COUNTY COUNCIL'S RESPONSE TO CONSULTATION ON THE FOLLOWING DEVELOPMENT PROPOSAL

Application no: 24/02058/F

Proposal: Full application for the proposed erection of a two storey building to form a 66 no. bedroom care home for older people with parking, access, landscaping and associated ground works.

Location: Land to the North of Anniversary Avenue, Graven Hill , Bicester, OX25 2BF

TITLE
Drainage Strategy

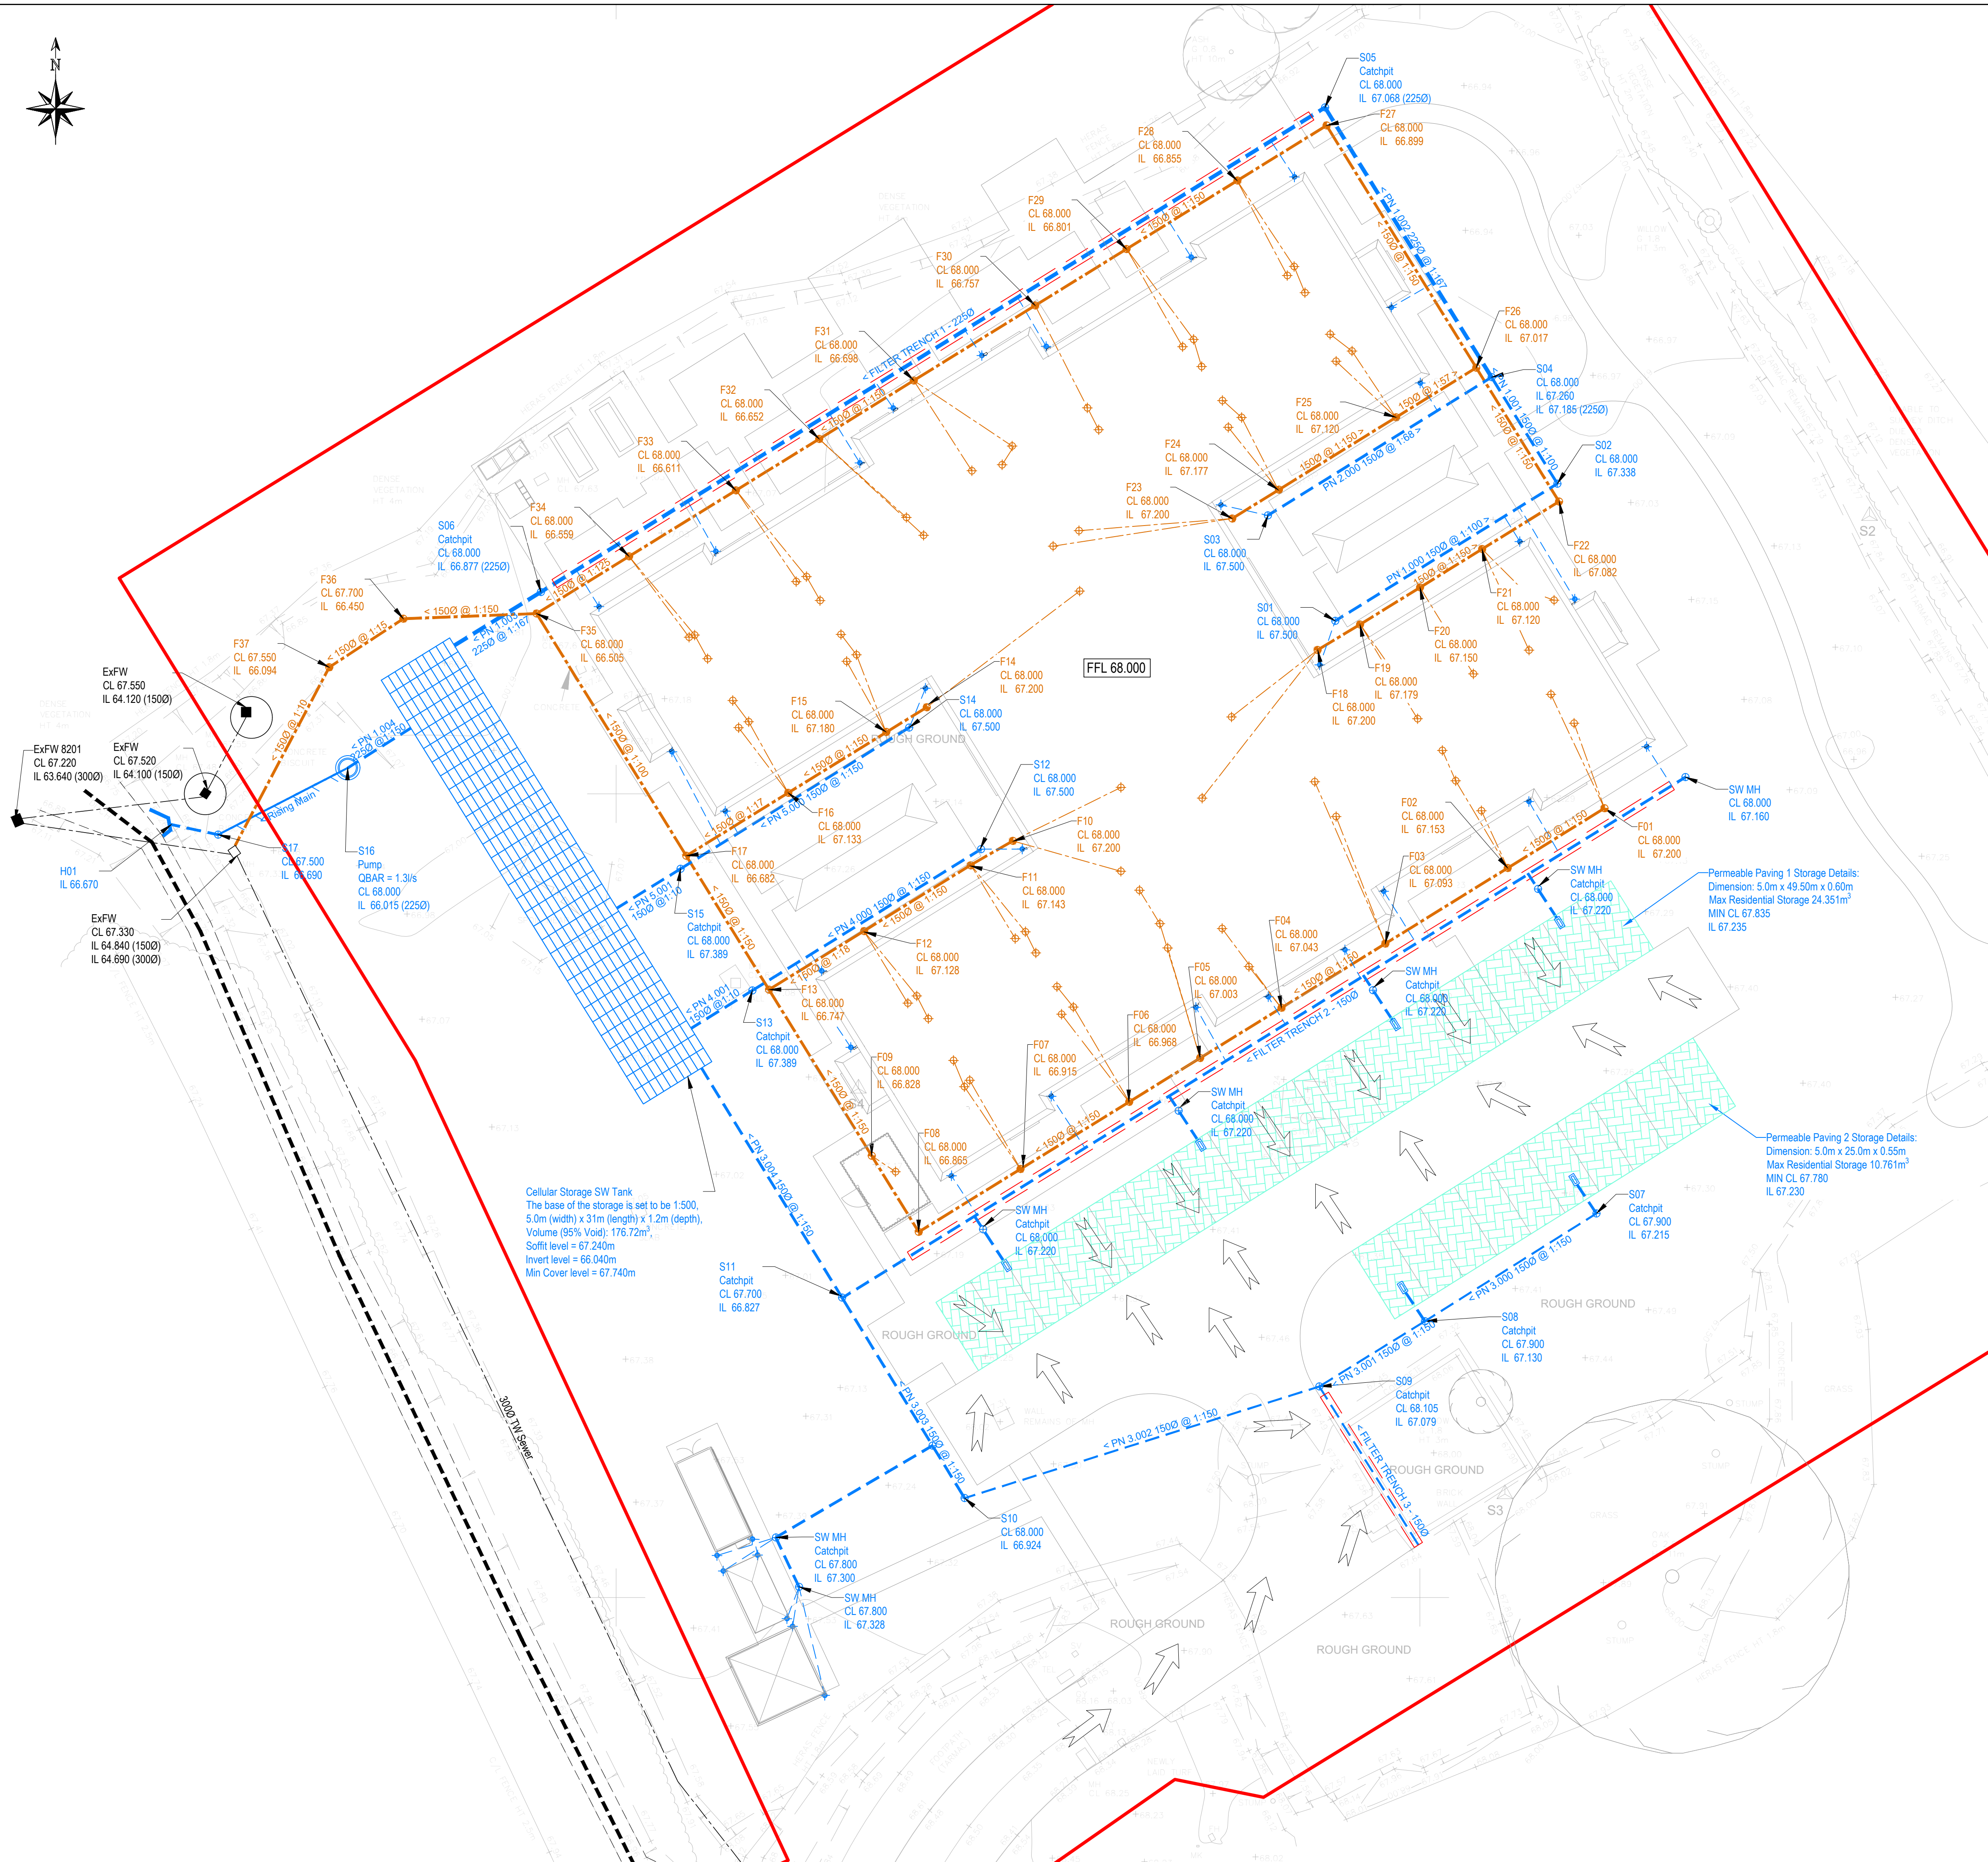
The drainage proposals have been updated with a variable rate pumped discharge, dependant on the level of water within the attenuation storage. Insufficient detail has been provided on how this will work in practice, whether the levels and discharge rates are appropriate relative to the calculated greenfield runoff rates, and whether the proposal is viable for operation and maintenance. Discussions are taking place with the applicant's consultant, but this remains unresolved currently. We are hoping to see a single rate discharge at Q_{bar} , however this would require additional attenuation storage.
